EPC STORMWATER REVIEW COMMENTS IN ORANGE BOXES WITH BLACK TEXT

VOLLMER ROAD (BARBARICK) - INTERIM CONDITION

GRADING AND EROSION CONTROL PLANS AUGUST 2022

VOLLMER ROAD (BARBARICK)
 -INTERIM CONDITION
 INITIAL/INTERIM GESC

VOLLMER ROAD (BARBARICK) -INTERIM CONDITION INITIAL/INTERIM GESC	BY	DATE							
	No.	REVISION							
	H-SCALE	1"=50'							
	V-SCALE	1"=5'							
	DATE	8/23/22							
	DESIGNED BY	CWC							
	DRAWN BY	DUG							
	CHECKED BY								
	SHEET	2	OF	6					
	JOB NO.	25188.01

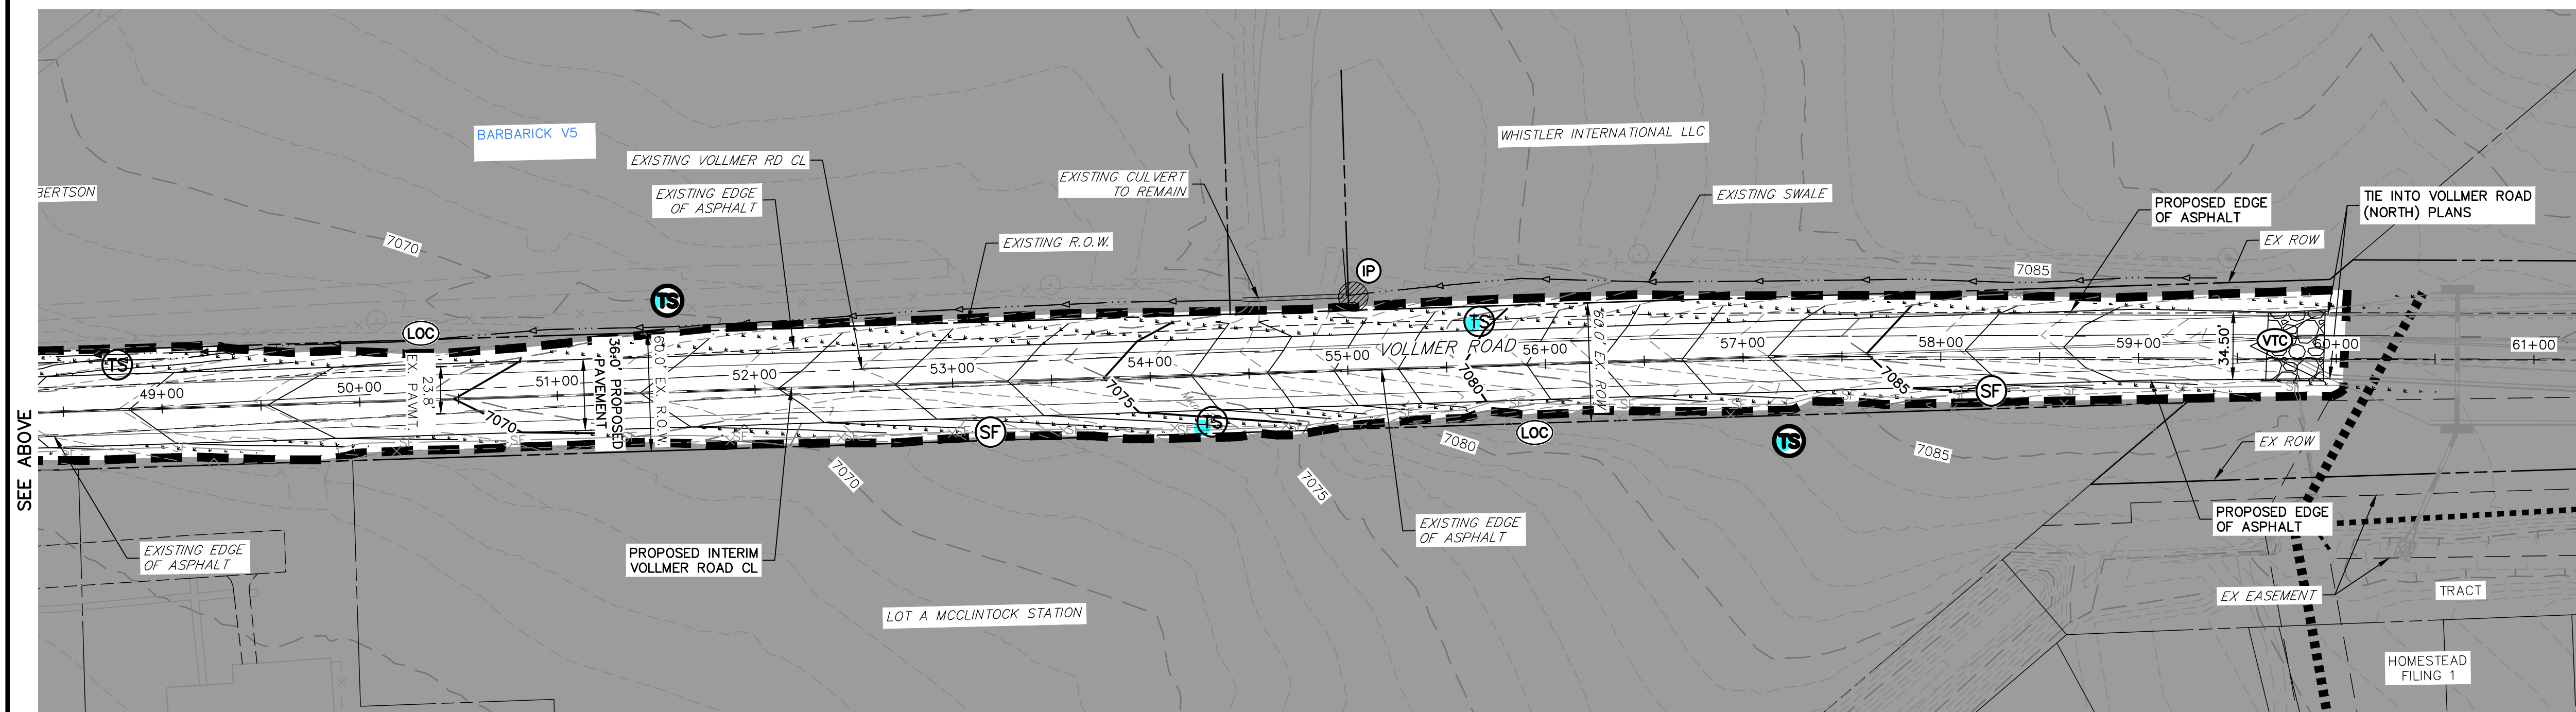
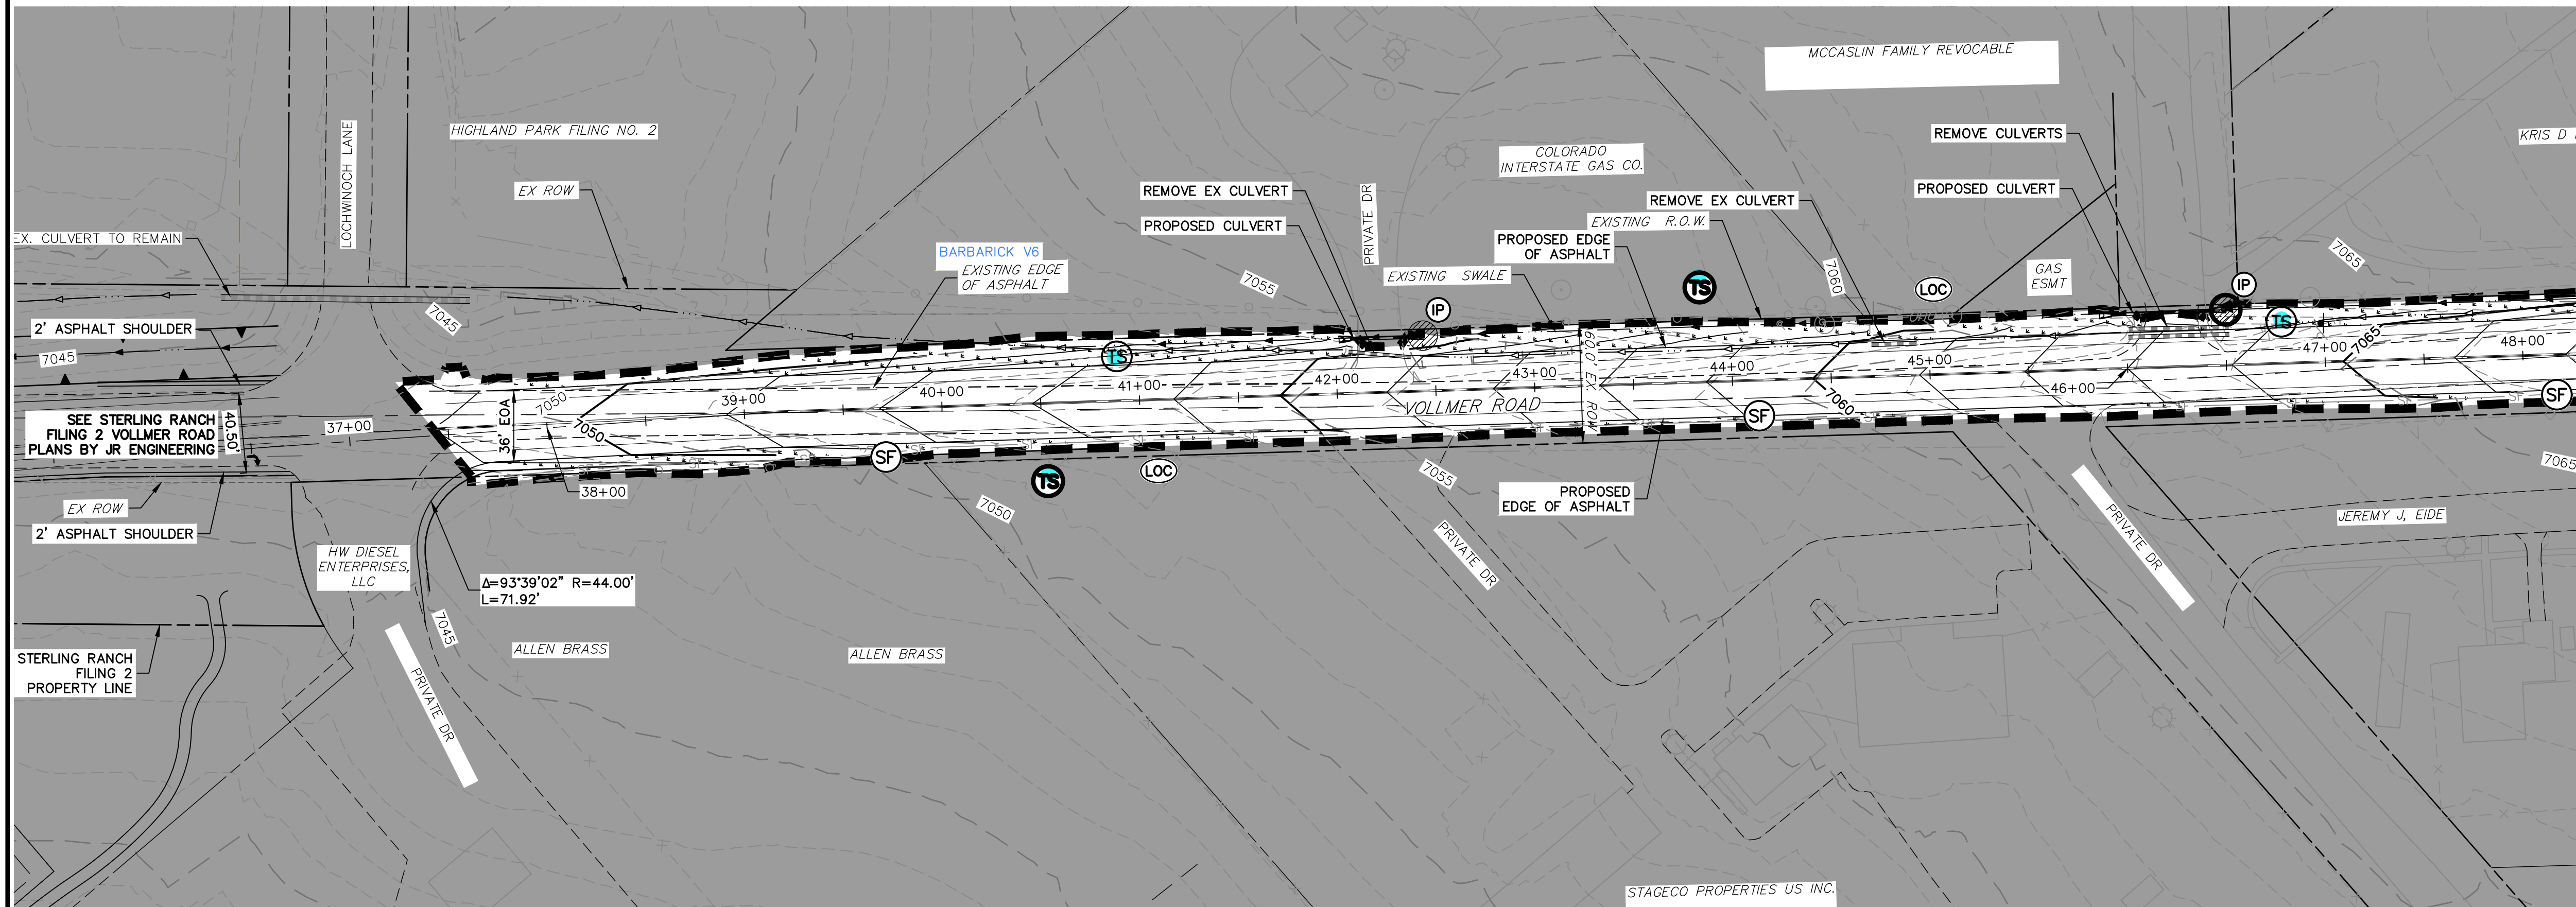
SWMP stated a different percent. Verify and update so both match.
